Re: MMC Staff Parking Garage | 222 St. John Street | Level III Site Plan Design Change

The purpose of this memorandum is to summaraze changes made within the attached revised design drawings since the initial Level III Site Plan Submission on June 22, 2018.

Drawing file: Drawings / 7_C-103_Grading & Drainage Plan - 2.pdf

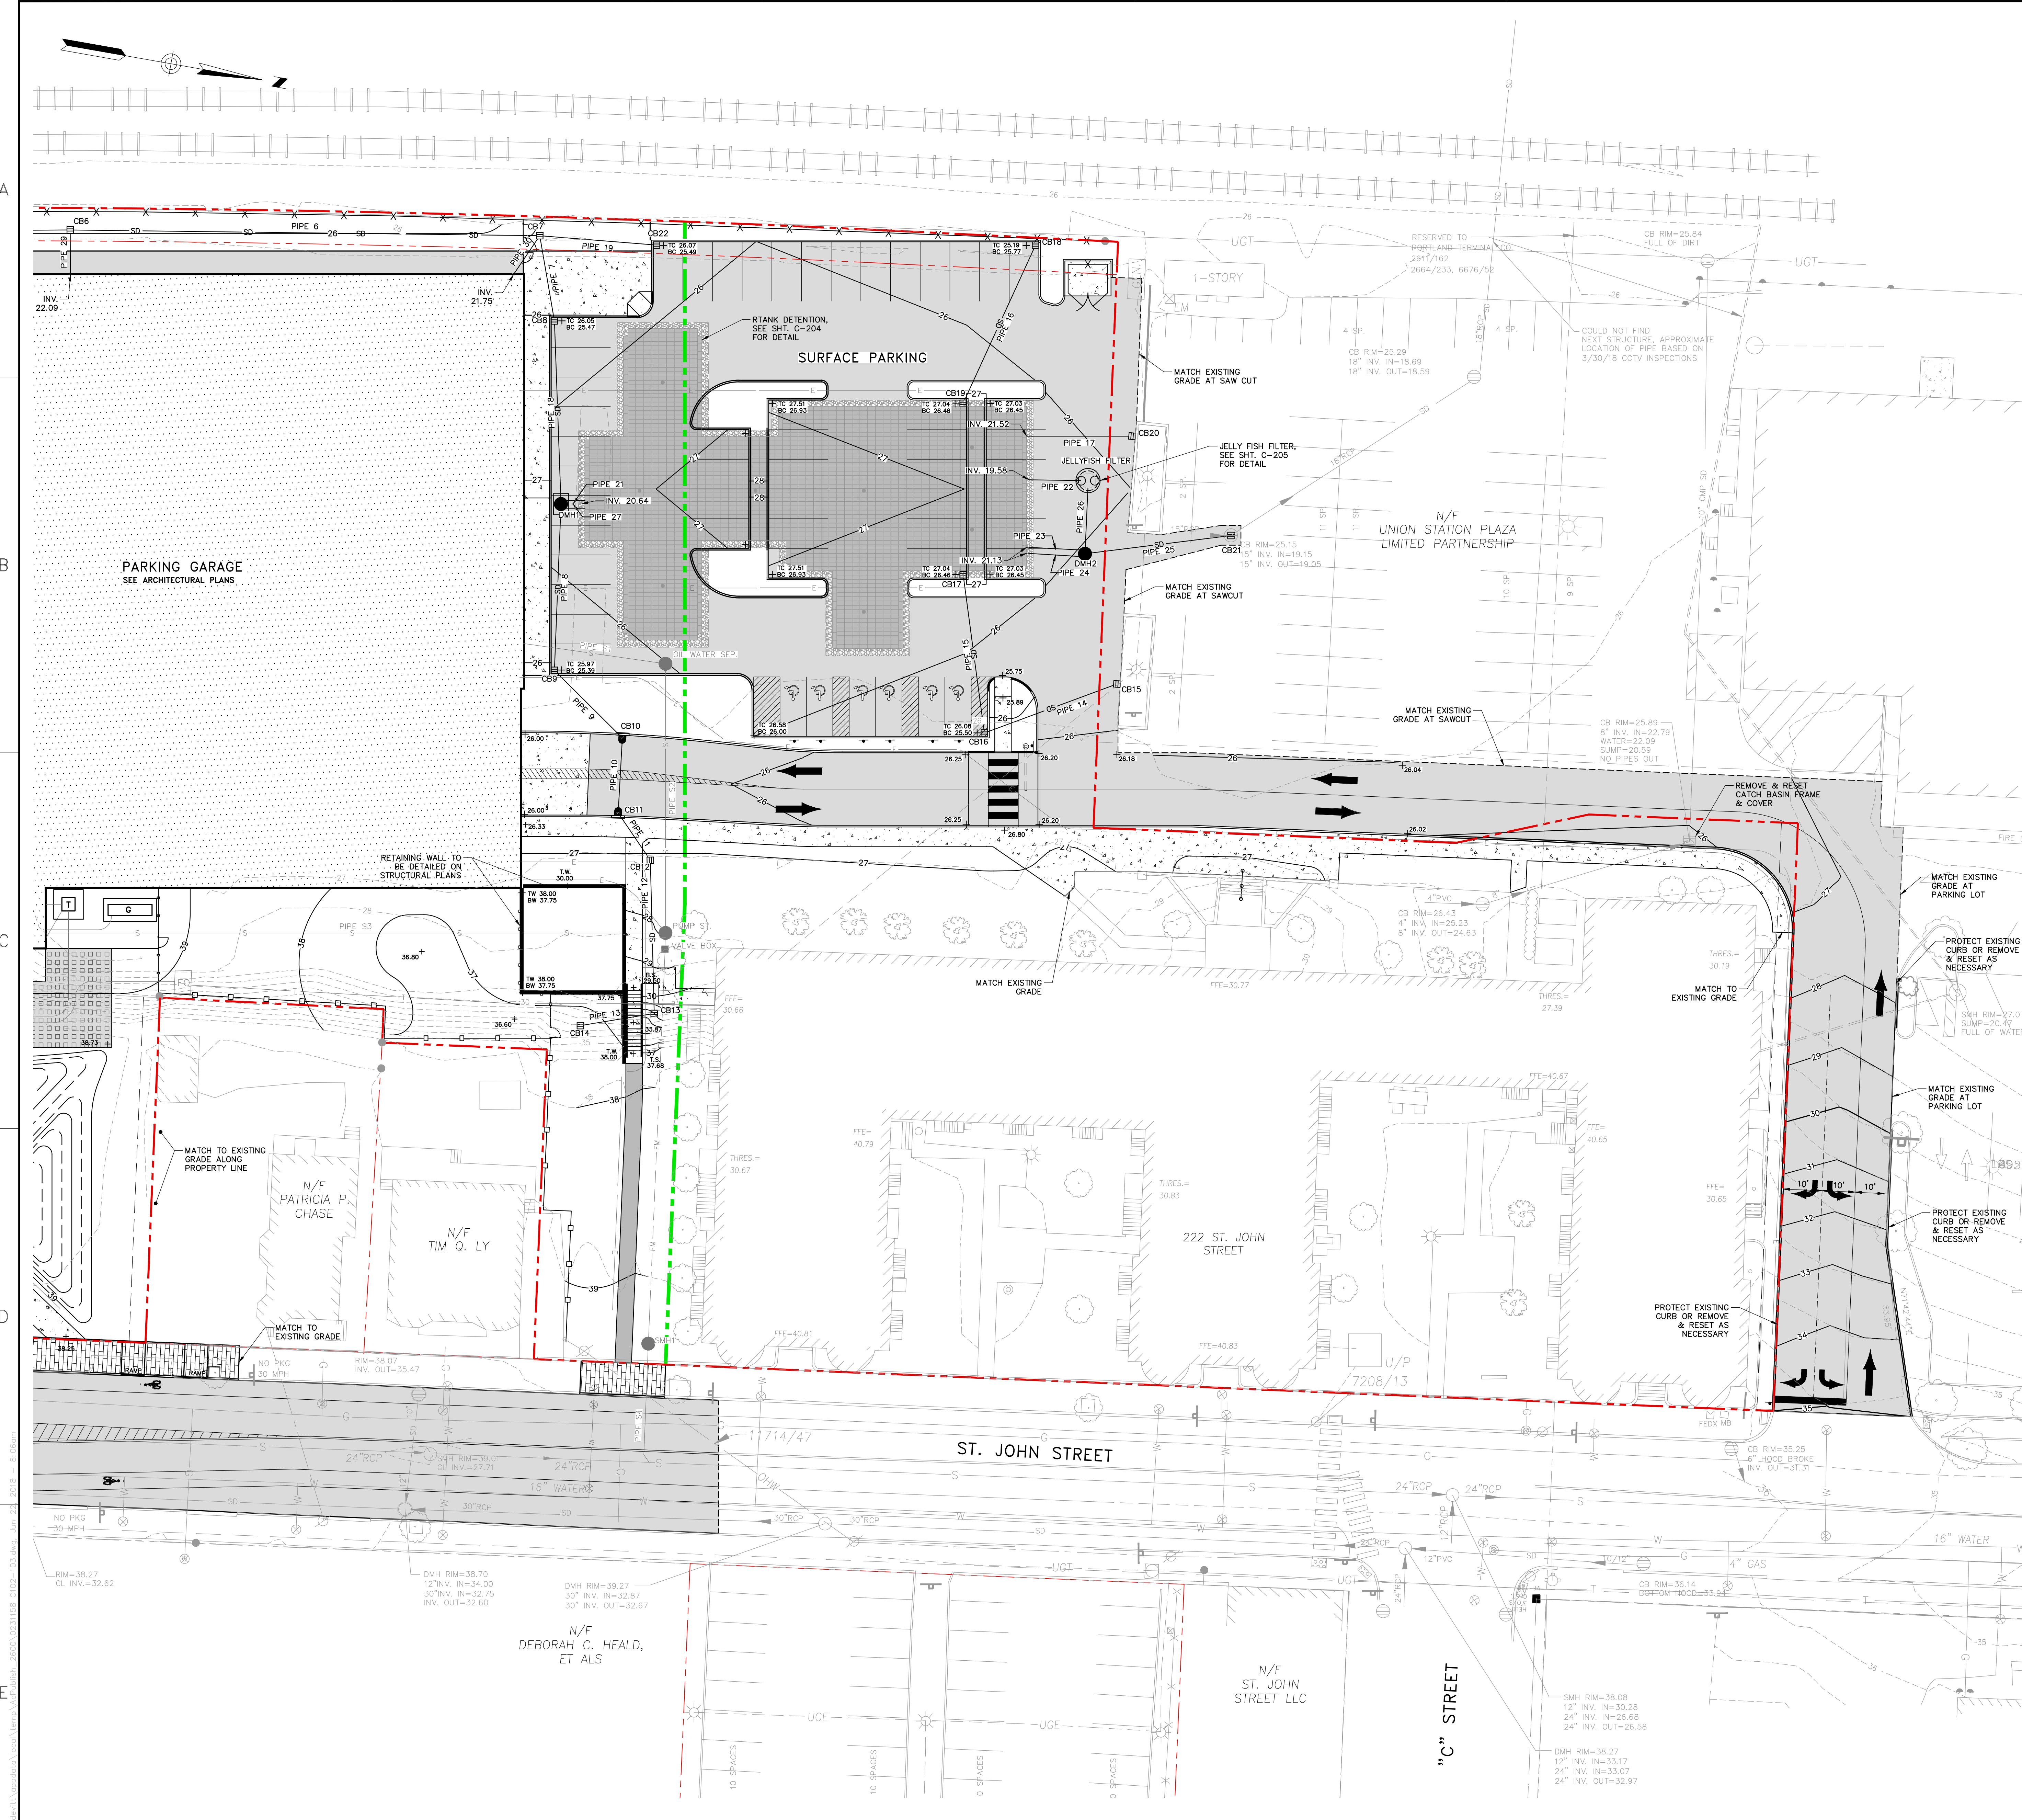
- Reconfiguration of grading adjacent to the pedestrian walkway from the northeast corner of the garage to St. John Street. Grading has been revised along the northern edge of proposed stairs; narrow strip of stone armoring added immediately adjacent to stairs to provide stabilization and prevent erosion.
- Revised grading along Union Station Plaza entrance, proposed grades have been revised to match existing grades.

Drawing file: Plans / 30 PS6 Level Parking Layout.pdf

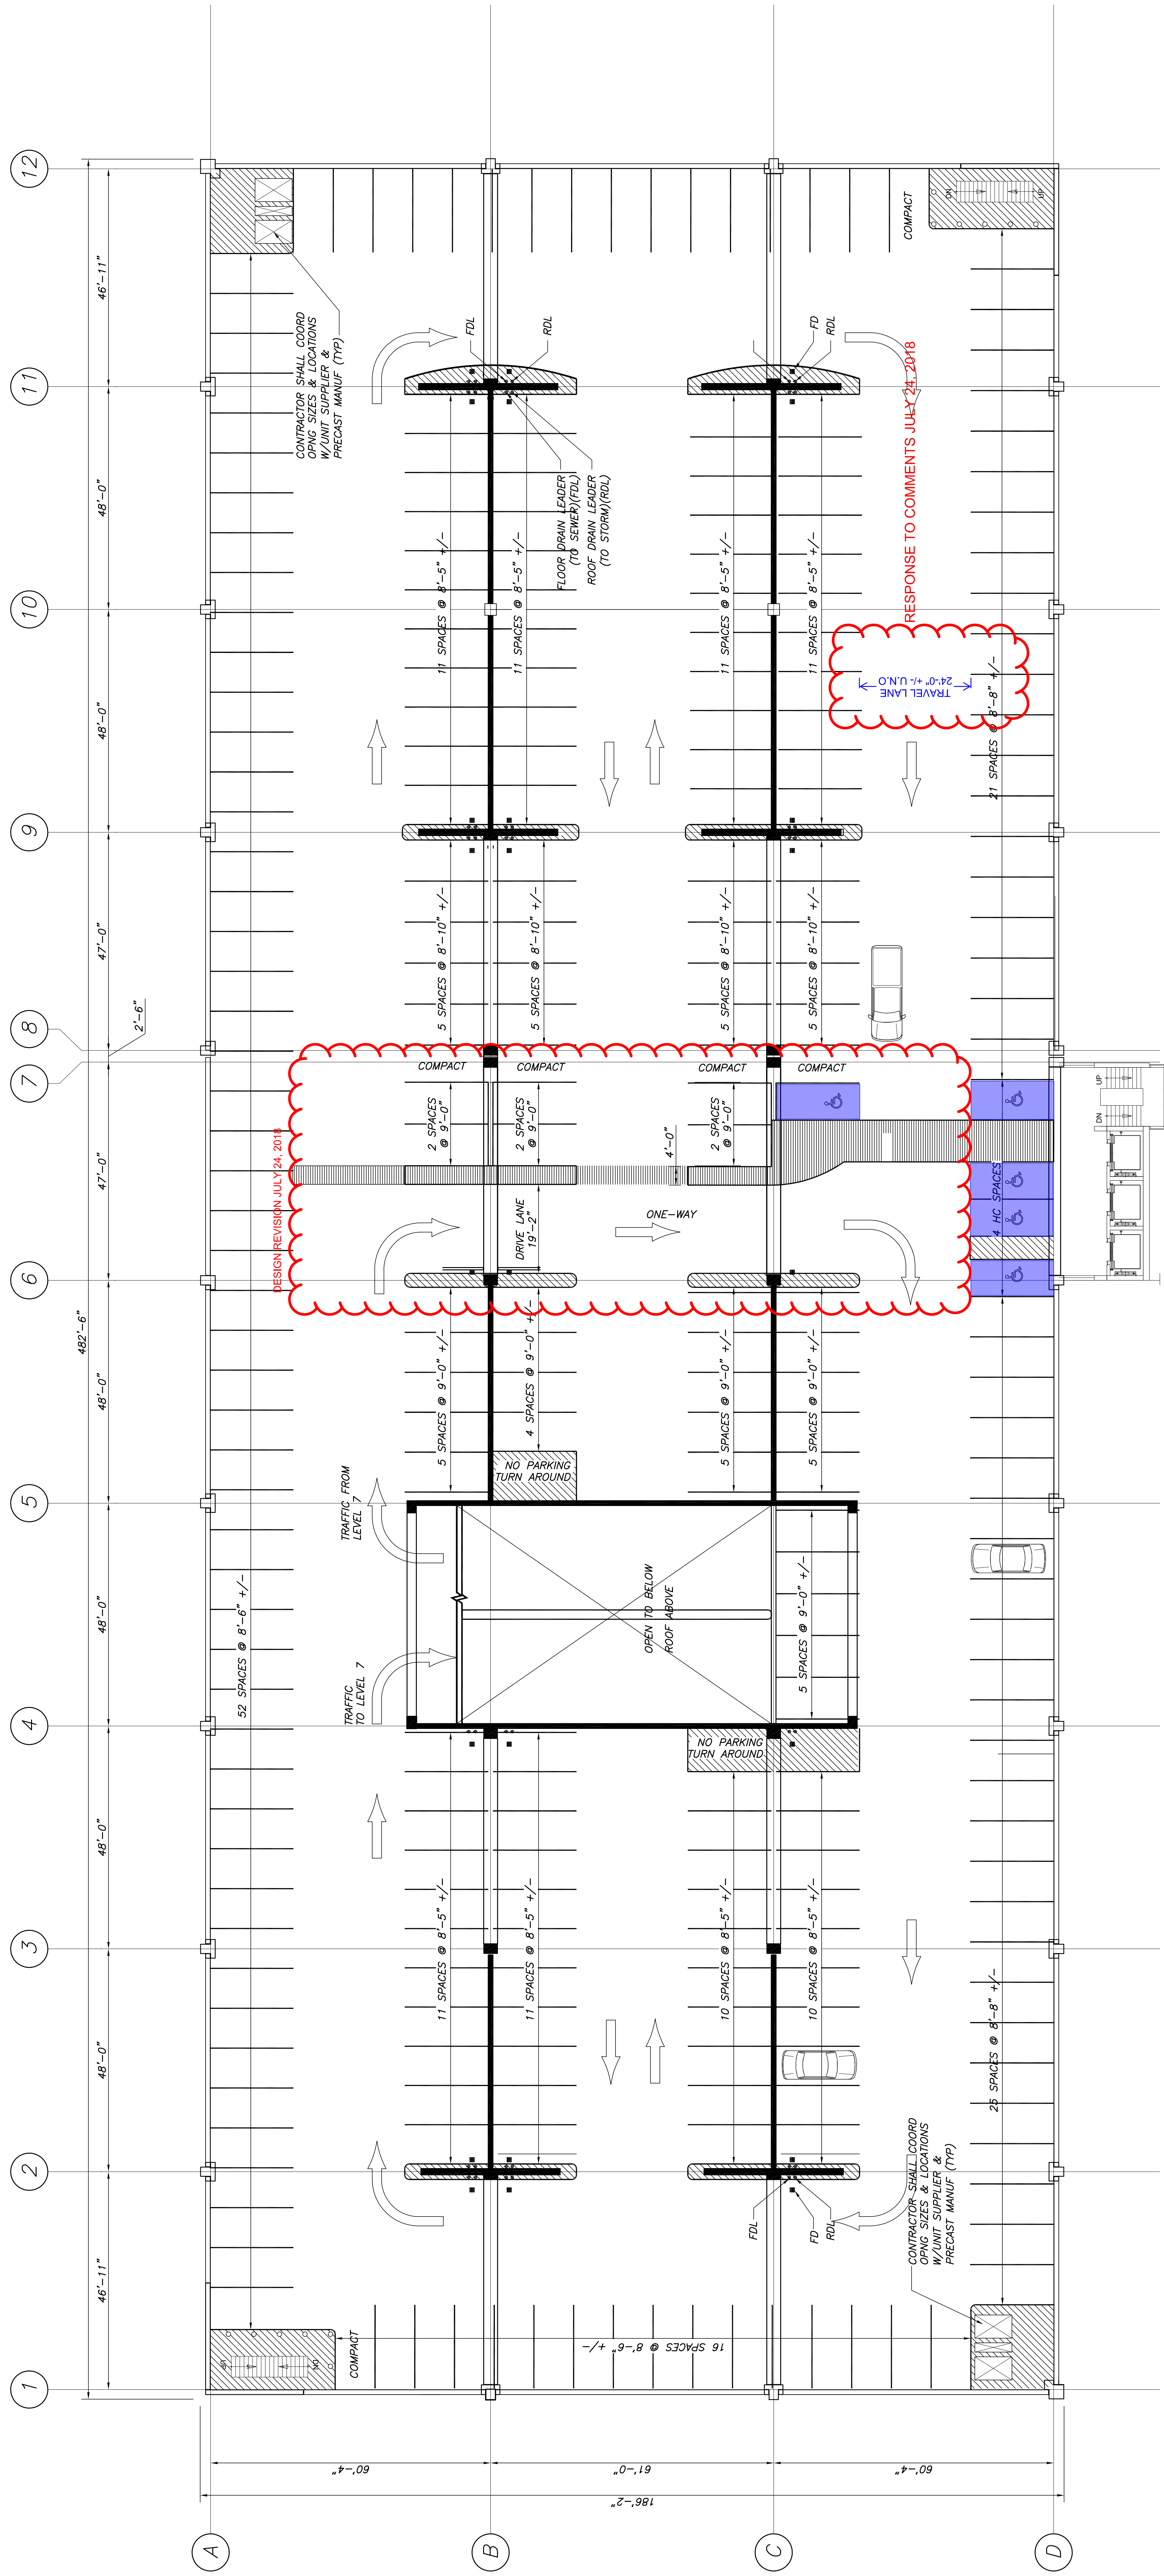
- Revised garage layout to accommodate separate 184 St. John Street entrance and parking spaces.
- Relocated van accessible spaces to level G and reduce floor to floor level 1 and level 2.
- Design layout changes within travel lane.
- Adaptational travel lane dimensions.
